3. **Project# 1009375**  
12DRB-70252 MAJOR – SITE  
DEVELOPMENT PLAN FOR  
BUILDING PERMIT

H & W ARCHITECTURE agent(s) for MATTRESS FIRM request(s) the referenced/above action(s) for all or a portion of Lot(s) 13-21, Block 8, **NORTH ALBUQUERQUE ACRES Tract A, Unit B**, zoned IP or SU-2/ C and IP or SU-2/ NC, located on the east side of PAN AMERICAN FREEWAY NE between GLENDALE AVE NE and ALAMEDA PL NE containing approximately 6.7438 acre(s). (B-18)[*Deferred from 9/12/12*]**INDEFINITELY DEFERRED.**

**HYDROLOGY DEVELOPMENT SECTION  
DEVELOPMENT REVIEW BOARD MEMO**

DEVELOPMENT REVIEW BOARD – SPEED MEMO

Sheet Title:  
**ELEVATIONS**  
Date: August 9, 12  
Drawn: S.T.WILDER  
Checked: S.T.WILDER

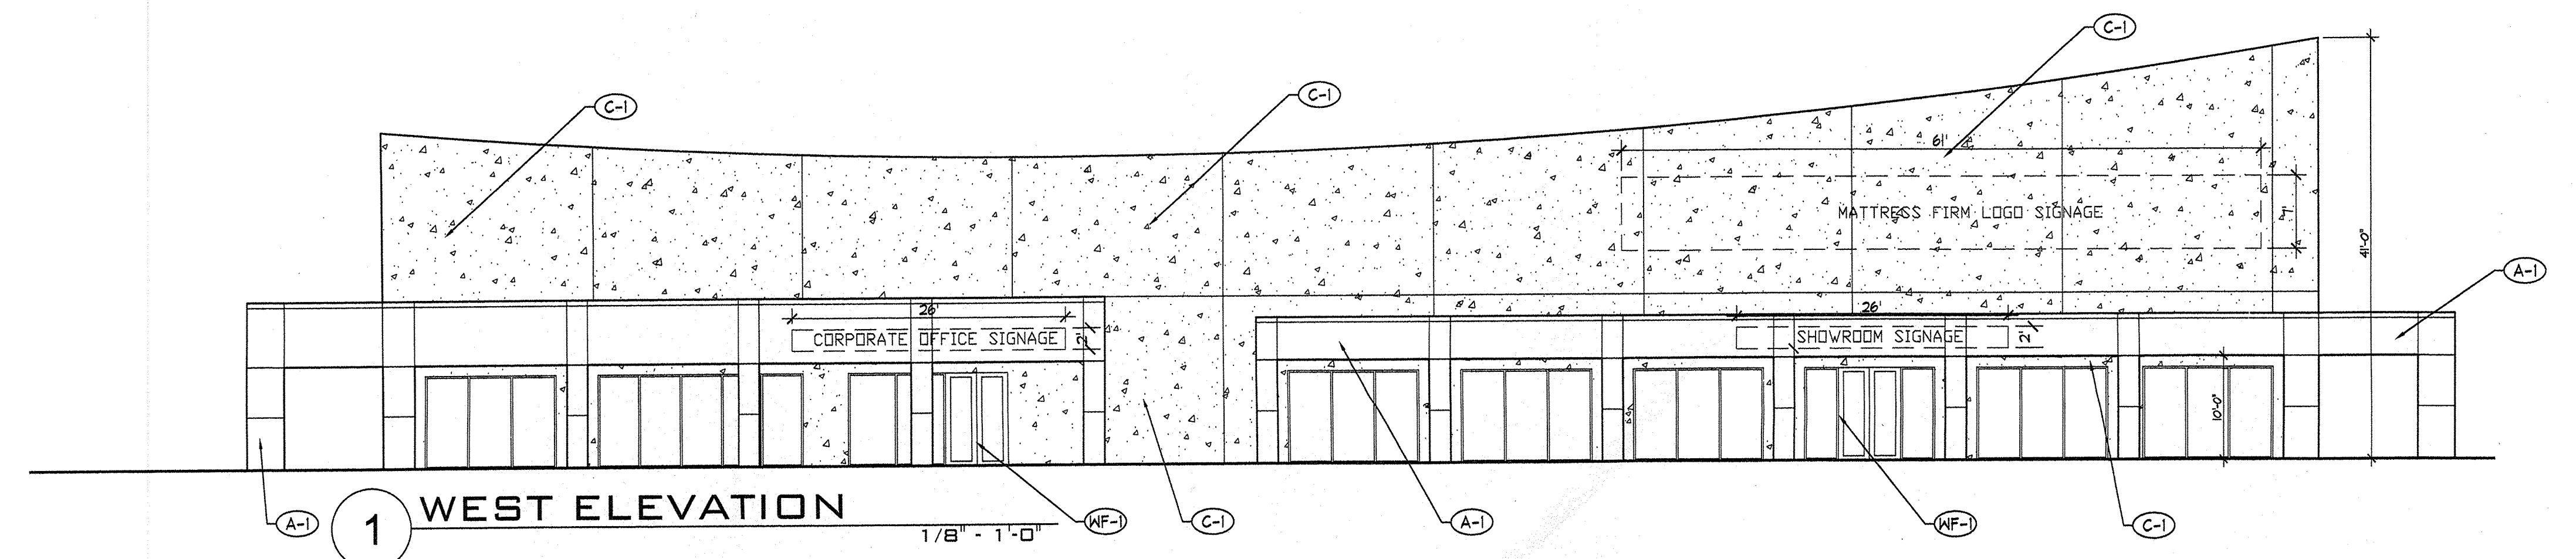
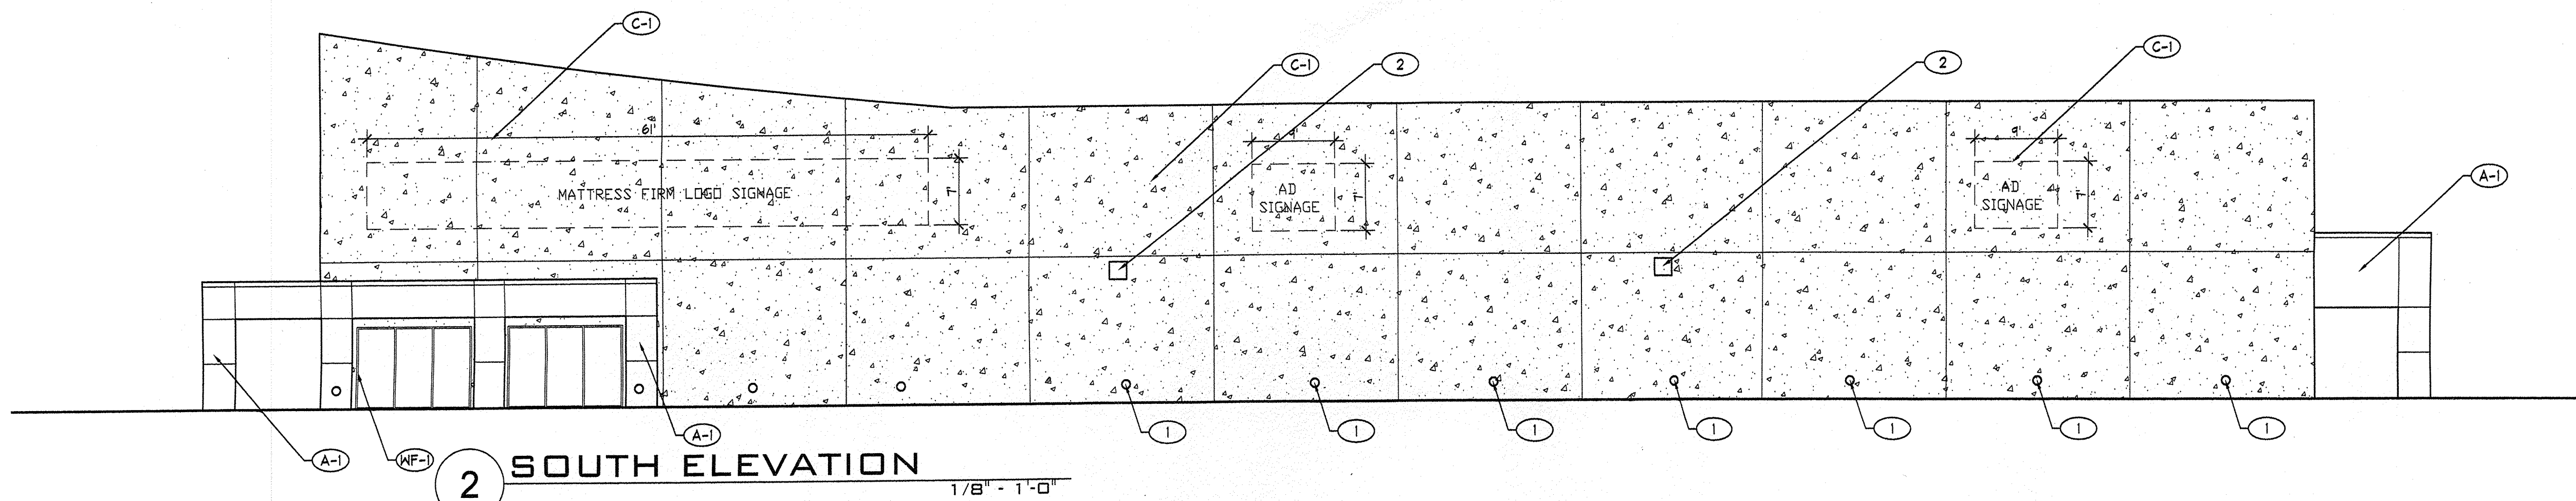
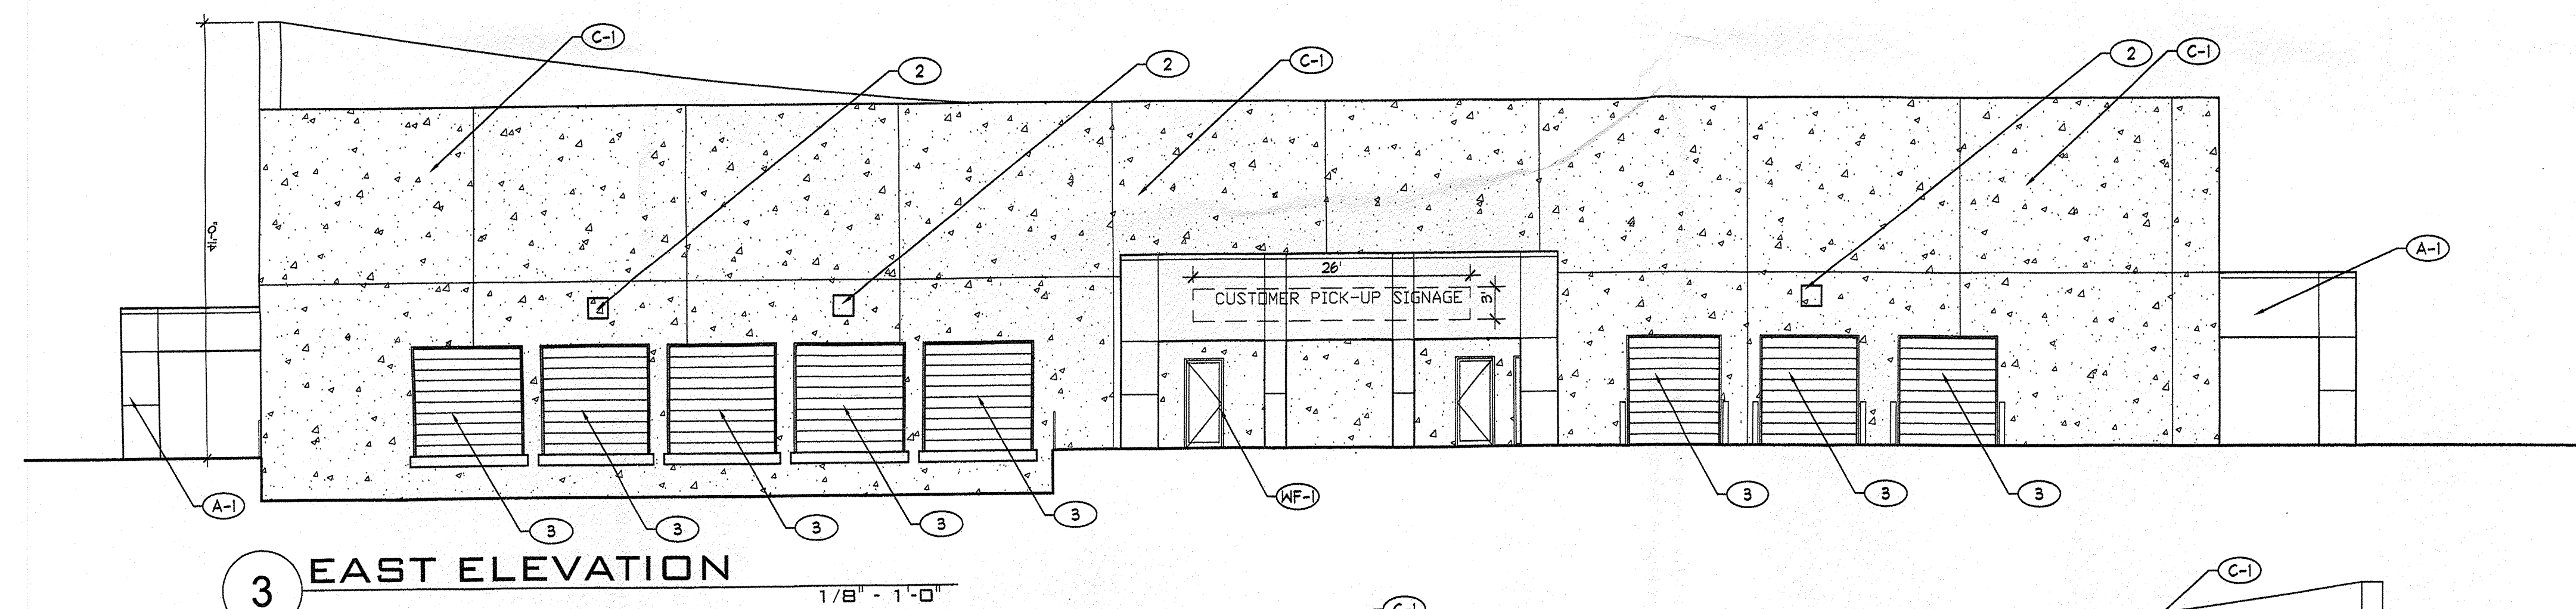
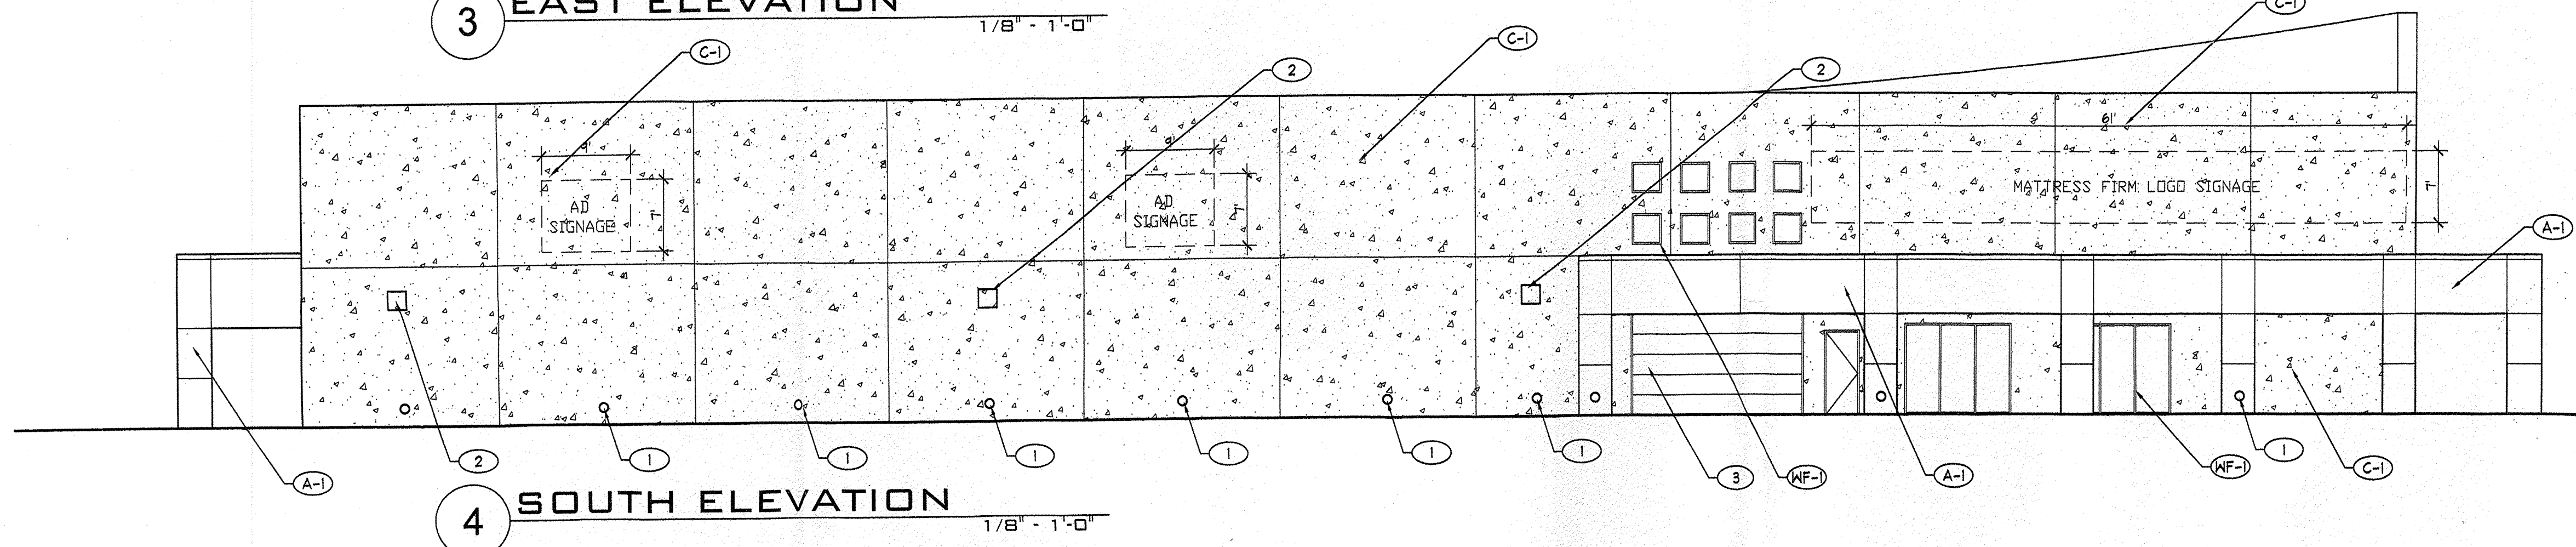
| <p><b>PLANNING DEPARTMENT</b><br/>Refer to comments from Zoning Enforcement for compliance with Zoning Code. plus any public hearing comments.<br/>Colors need to be called out on building elevation sheets. Buildings A and B do not conform to site plan for subdivision Design Requirements. The use of metal wall panels exceeds the "accent" as described in the Design Requirements, and CMU blocks are not included as an acceptable material.</p>  |
